<b>Application Ref:</b>	3/2025/0536			 Ribble Valley Borough Council <small>www.ribbonvalley.gov.uk</small>
<b>Date Inspected:</b>	28/08/2025	<b>Site Notice:</b>	N/A	
<b>Officer:</b>	MC			
<b>DELEGATED ITEM FILE REPORT:</b>				<b>APPROVAL</b>

<b>Development Description:</b>	Part retrospective outline planning permission to demolish the existing bungalow and proposed new detached self-build 4/5 bedroom house with access applied for (all other matters reserved).
<b>Site Address/Location:</b>	Dale Hey Bungalow, Preston Road, Ribchester, PR3 3XL

Dwng No. **A4578-PL03** Rev. **B**

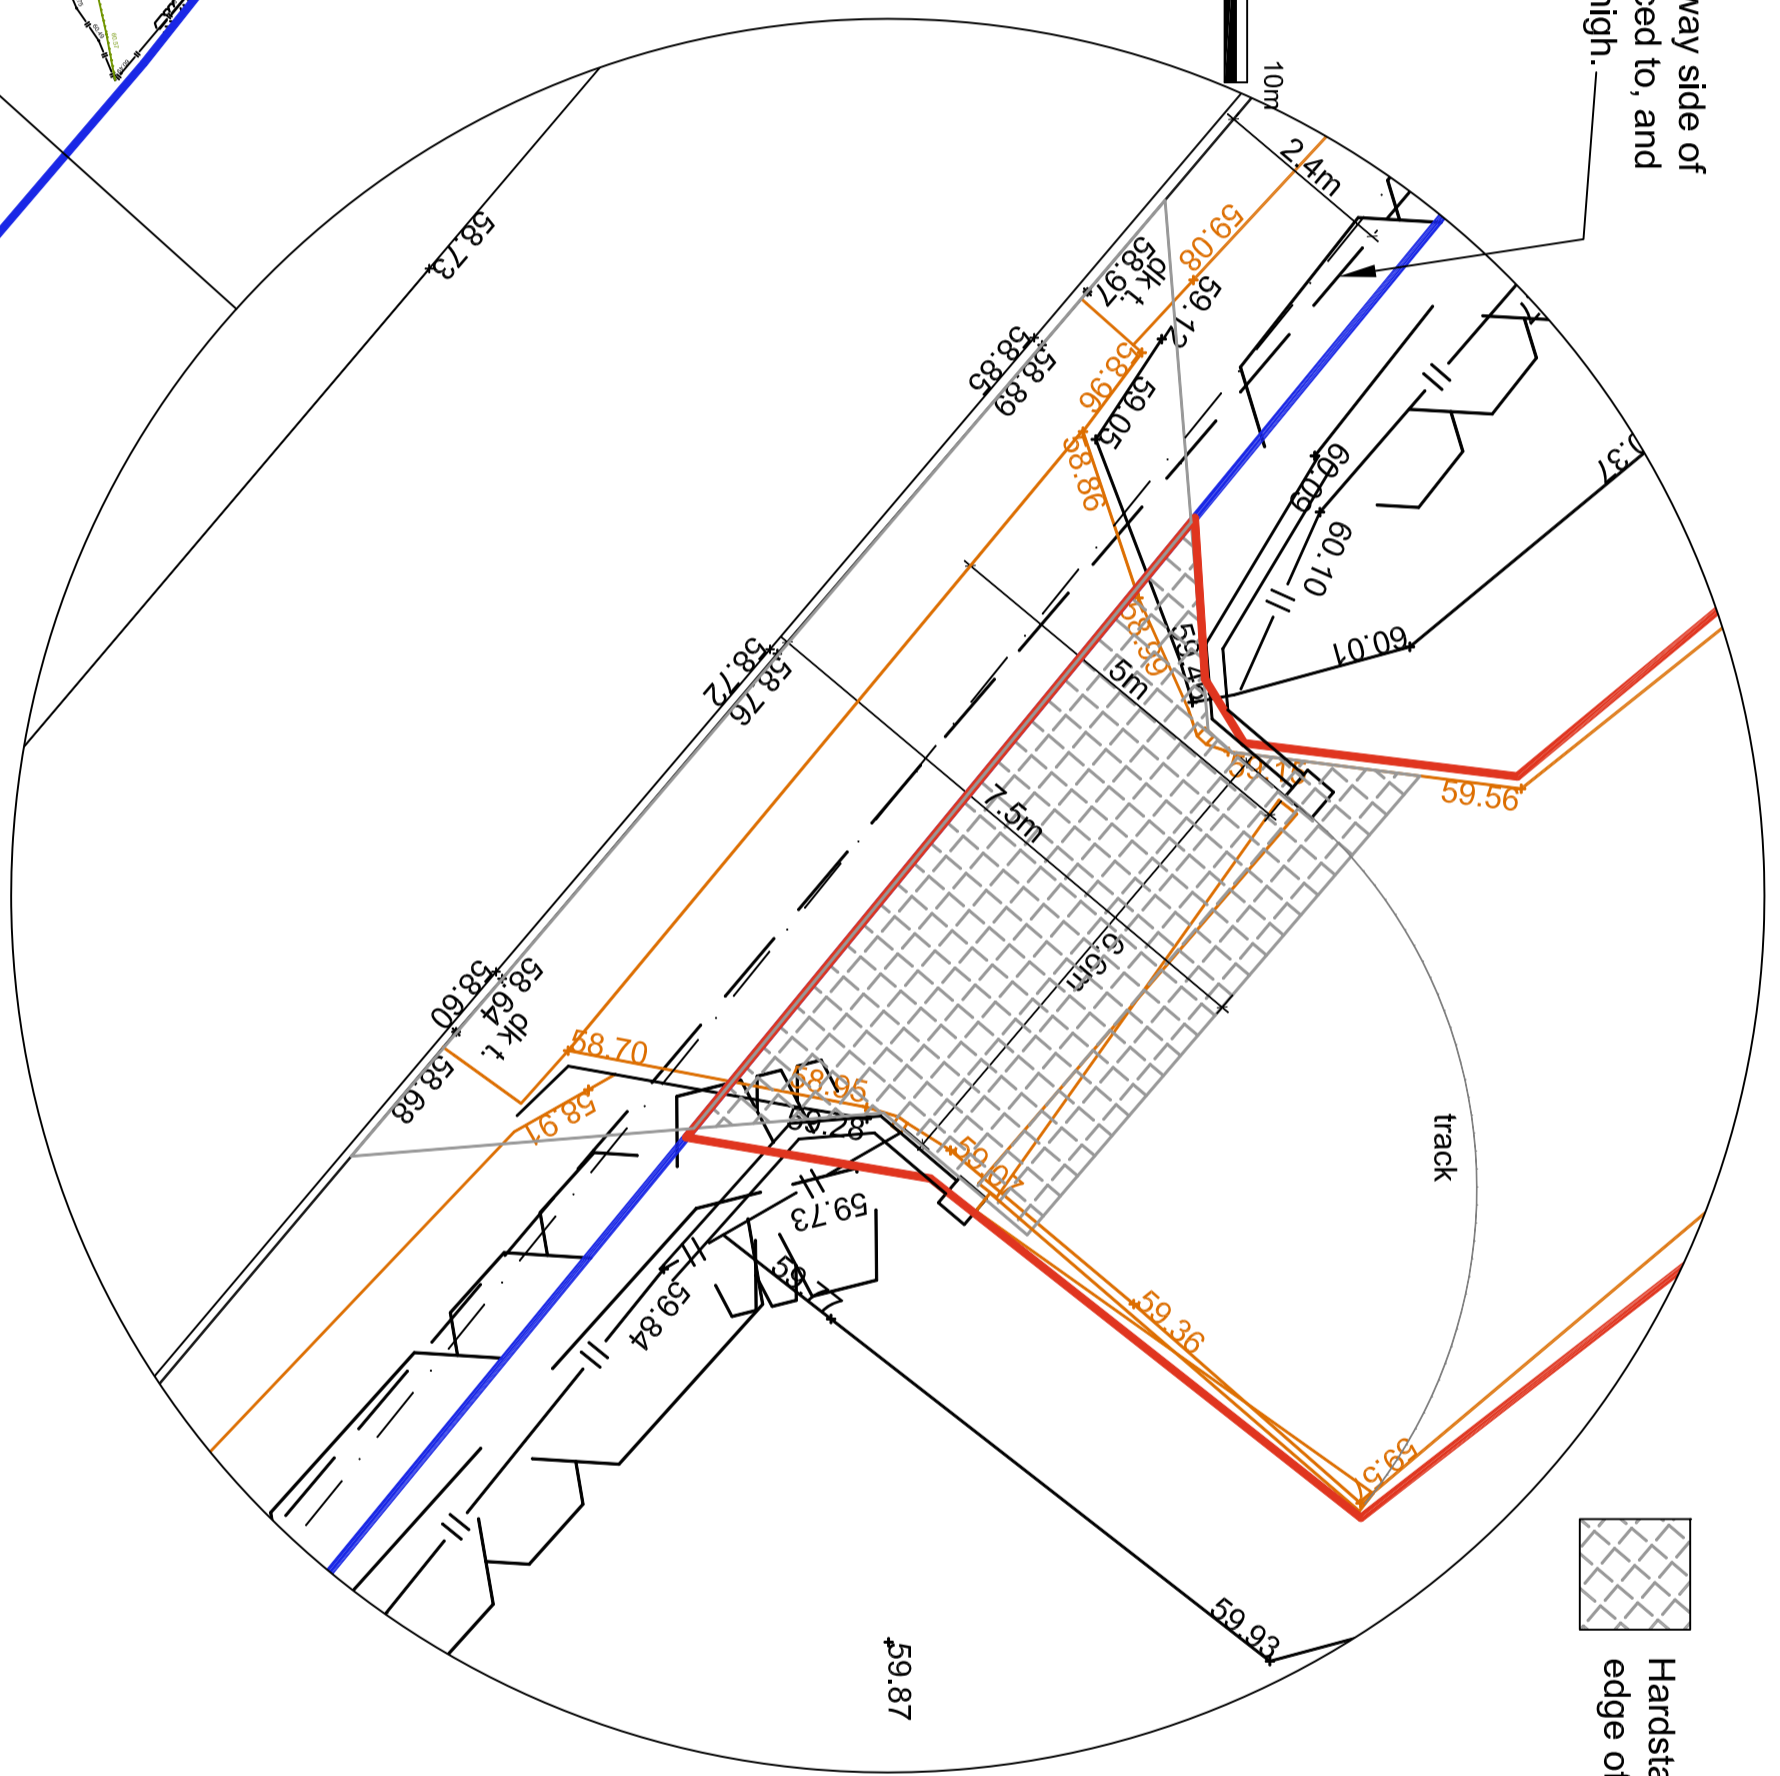
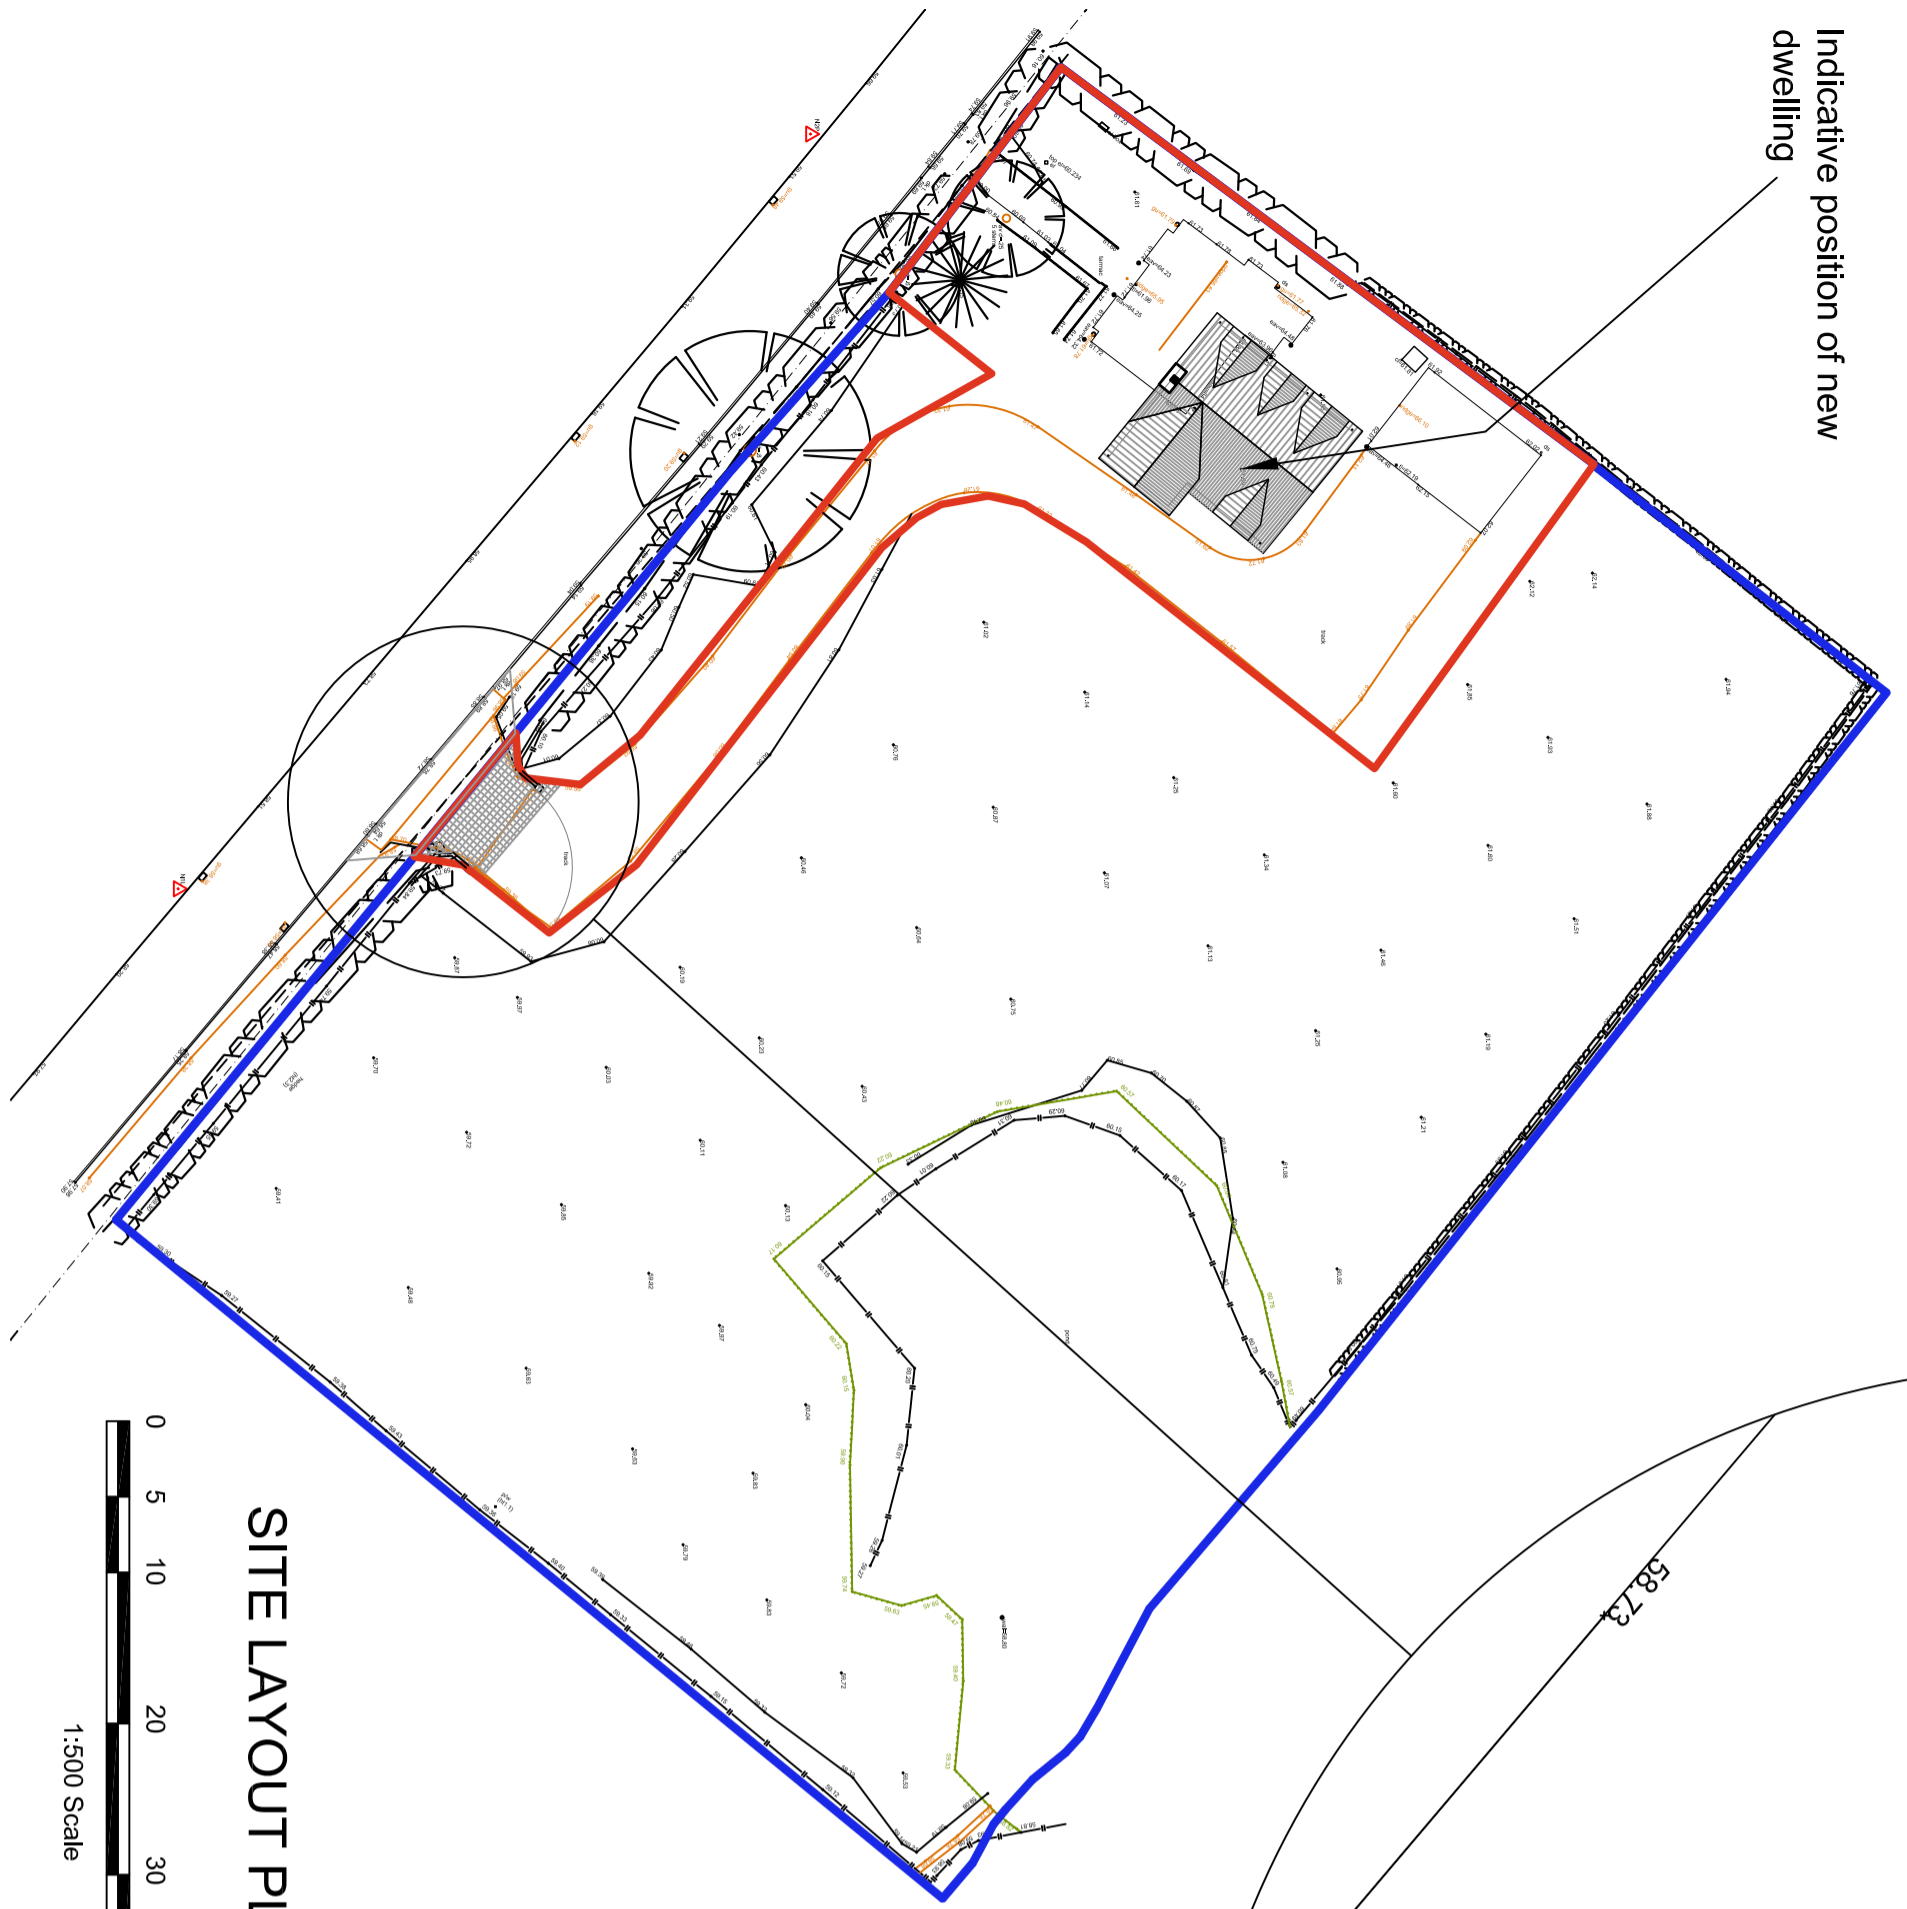
The proposed access as indicated on the drawing shows walls at the site access extending from 1m in height at the road side to 2.4 metres approximately further within the site. As this relates to boundary treatments this would be a matter to be considered at reserved matters stage when landscaping is applied for. In principle however this is not considered to be out of keeping with the character of the surrounding area, where there are stone walls running parallel to the road at Dale Hey Touring Park. The stone walling would only be 1.1 in height closest to the road and the land levels would be slightly reduces to create a more gentle slope. Such works are not considered to result in any significant detrimental harm to the character and appearance of the open countryside, given the presence of similar boundary treatments within the vicinity of the site.

In addition, the submitted site plan shows the outline of an existing garage at the site. It is unclear from the submitted information within the application form whether this is to be demolished or retained. As such, it would seem appropriate to include a condition to ensure that details are provided at the reserved matters stage for the buildings demolition or retention for clarity in the interests of visual amenity.

The Local Highway Authority (LHA) have been consulted on the application. Lancashire County Council acting as the LHA originally objected to the development on highway safety grounds. A number of amendments to the access have now been made and the whilst the LHA consider these amendments to be acceptable, they note that the proposed new access will need to be constructed as part of an appropriate legal agreement with Lancashire County Council as the Highway Authority. There has been one comment made by the occupiers of a neighbouring property. However, when the Planning Officer visited the site, it was noted that this has not been fully implemented. As such, the recommended conditions in relation to the proposed access alterations are necessary and relevant to the application in the interest of highway safety.
